A. R. ROBINSON
Dip. Arch. (Dunelm), A.R.I.B.A. (Rtd.)
14 MANDEVILLE RISE
WELWYN GARDEN CITY
HERTFORDSHIRE
AL8 7JU

19. 11. 2013

RE: N6/2013/1938/MA AMENDED PROPOSED ALTERATIONS TO CAMPUS EAST

Plan of Entrance
Scale 1:25

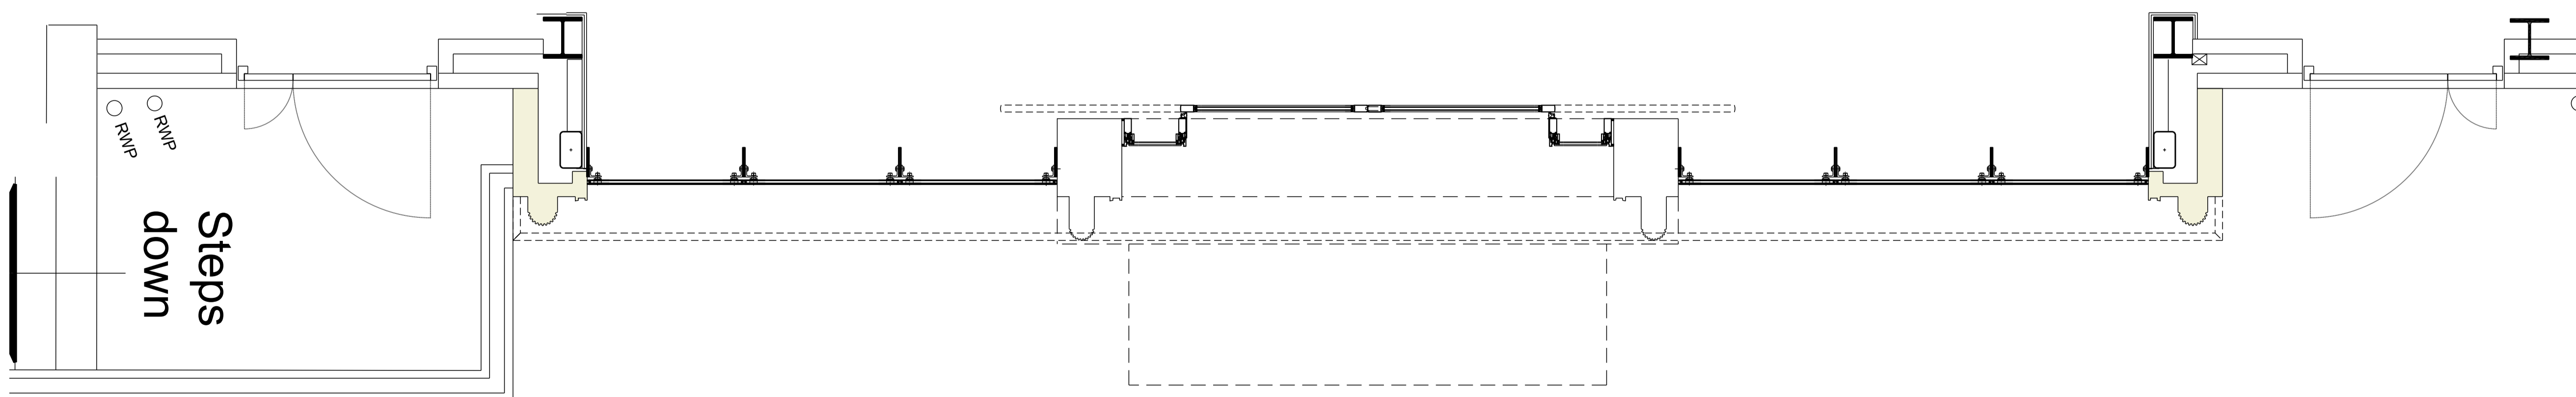
Having been informed by WHC staff that the plans have not been amended, the principal features of the design, namely the Council Chamber and the proposed arch do still not align.

The fact that the elevations of the existing wings are not symmetrical should not impose symmetry on the new elevation.

The amended architectural treatment using brick either side of the arch suggests that the whole of the new elevation should be treated with this material and the proposed arch be abandoned.

I therefore object to the amended proposal.
